Mountain View Electric Association, Inc. (MVEA) has these comments about the following:

Project Name: Retreat at TimberRidge, Filing #1

Project Number: SF 199

RETREAT AT TIMBERRIDGE  
 FILING NO. 1  
 JOB NO. 1185.00  
 FEBRUARY 22, 2019  
 SHEET 1 OF 5

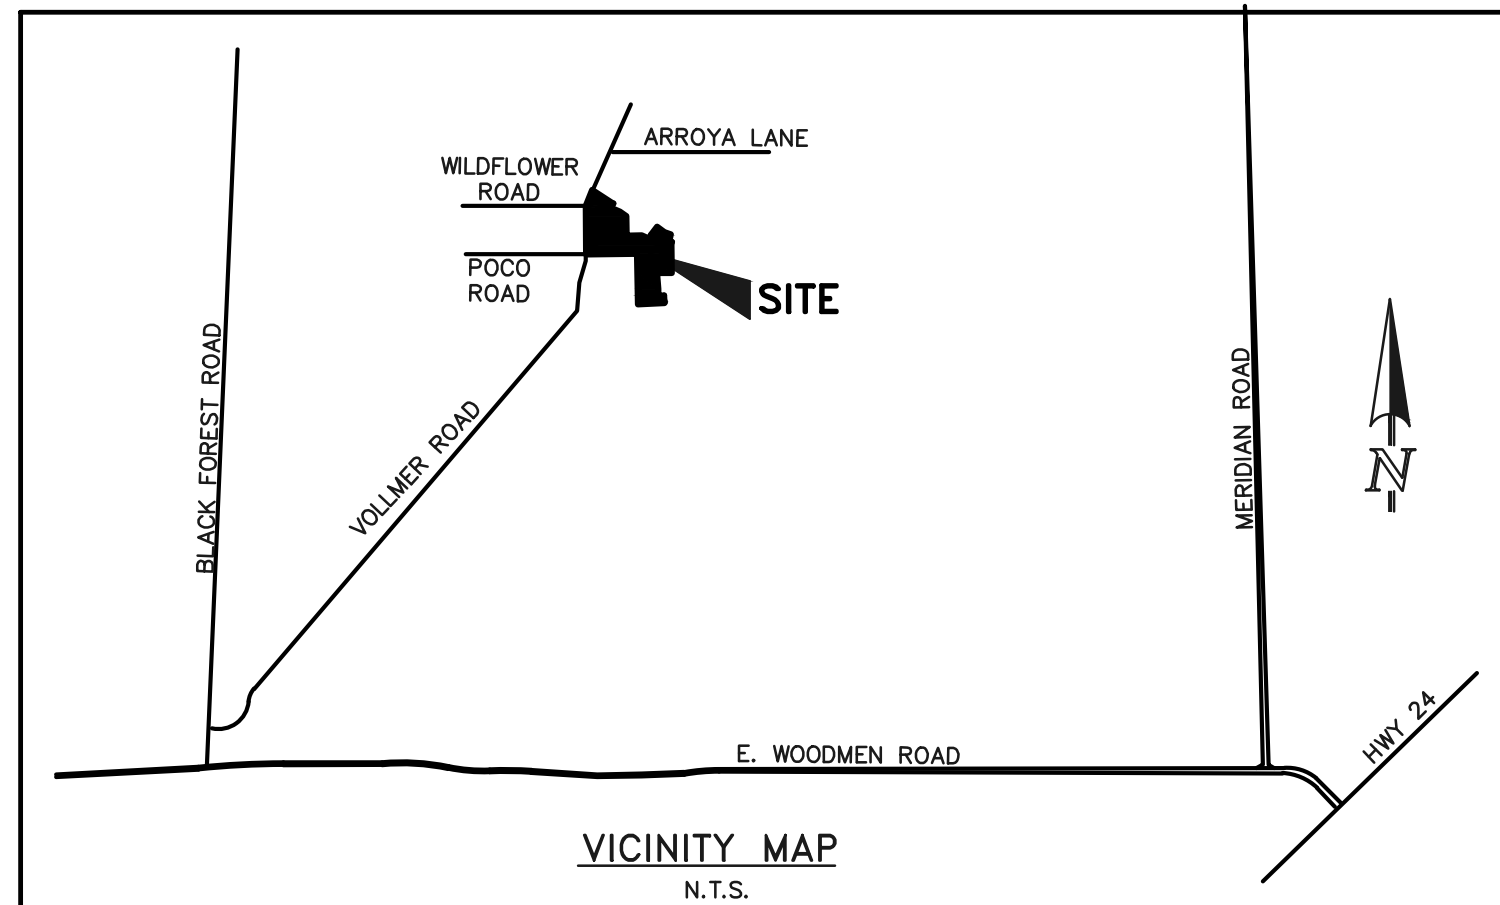
MVEA requests a ten (10) foot front, rear and side lot line utility easement on lots one (1) acre and larger. Residential lots less than one (1) acre MVEA request a ten (10) foot front and rear lot line utility easements along with five (5) foot each side lot line utility easement. MVEA also request a twenty (20) foot exterior subdivision utility easement.

RETREAT AT TIMBERRIDGE  
FILING NO. 1  
JOB NO. 1185.00  
FEBRUARY 22, 2019  
SHEET 2 OF 5

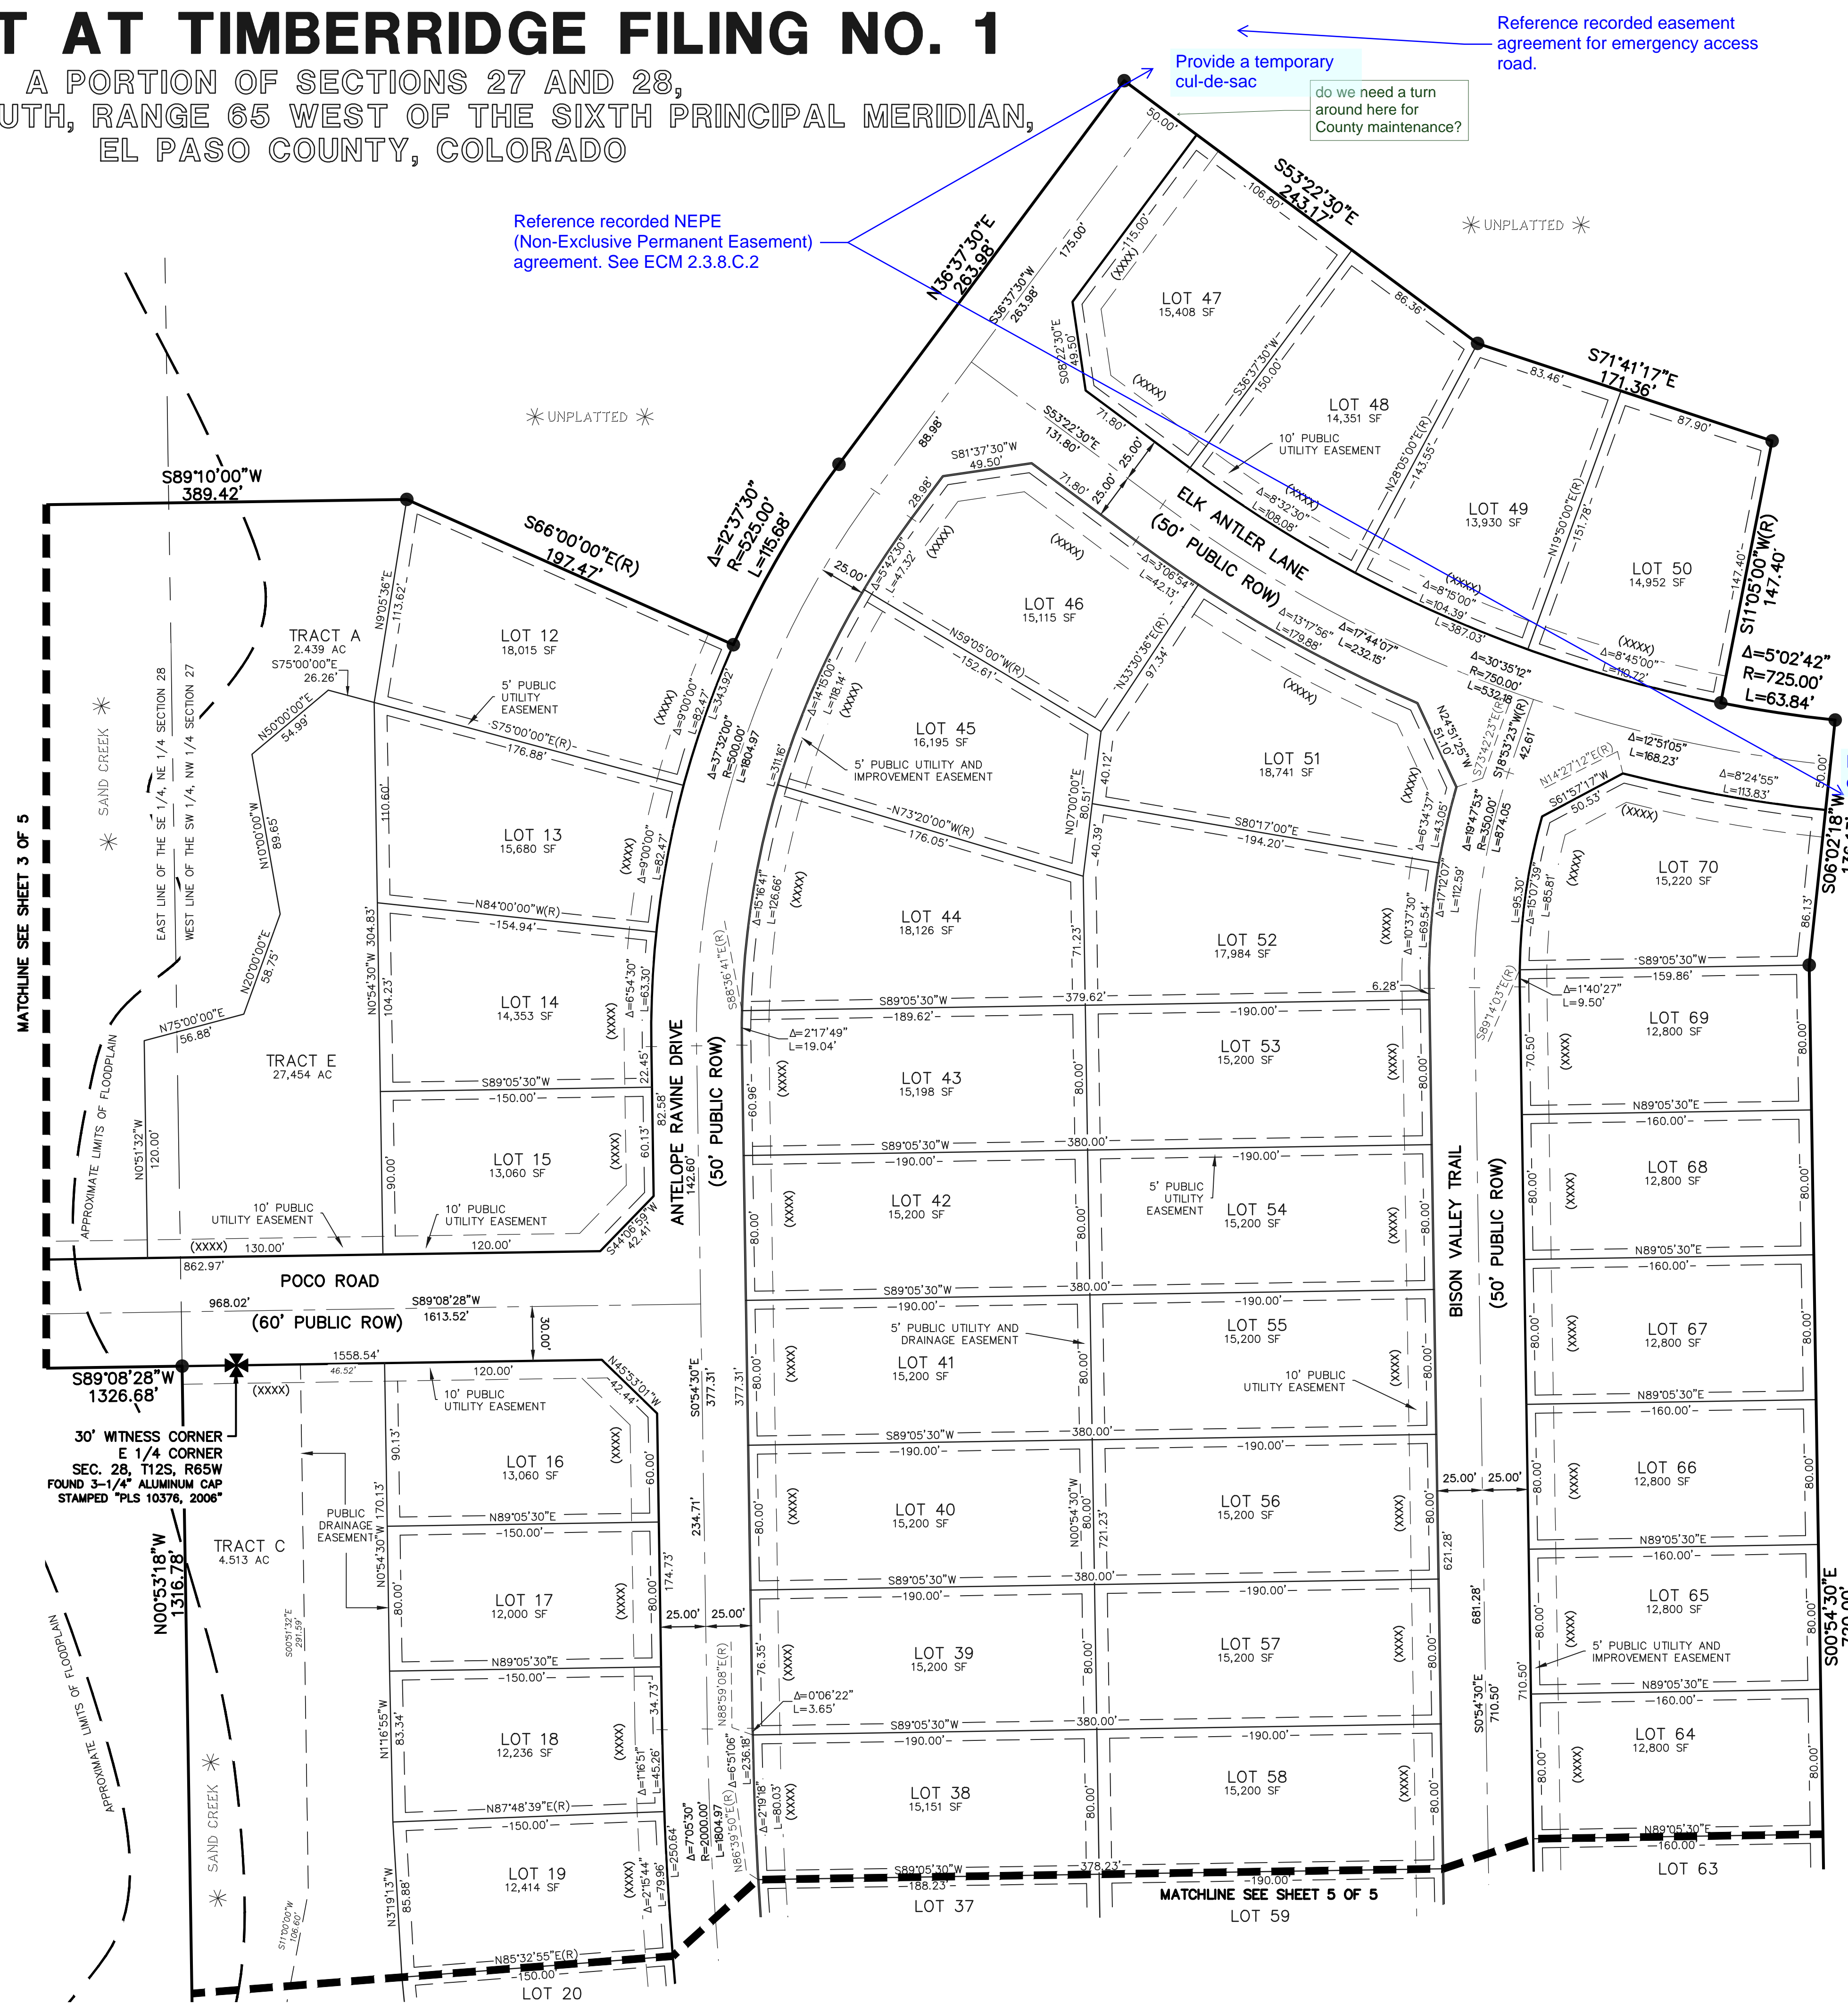
MVEA request that the ten (10) foot public utility easement continues around the south and west tract lines of Tract F and that the ten (10) foot public utility easements continues around the cul-de-sac on the north tract line of Tract D.
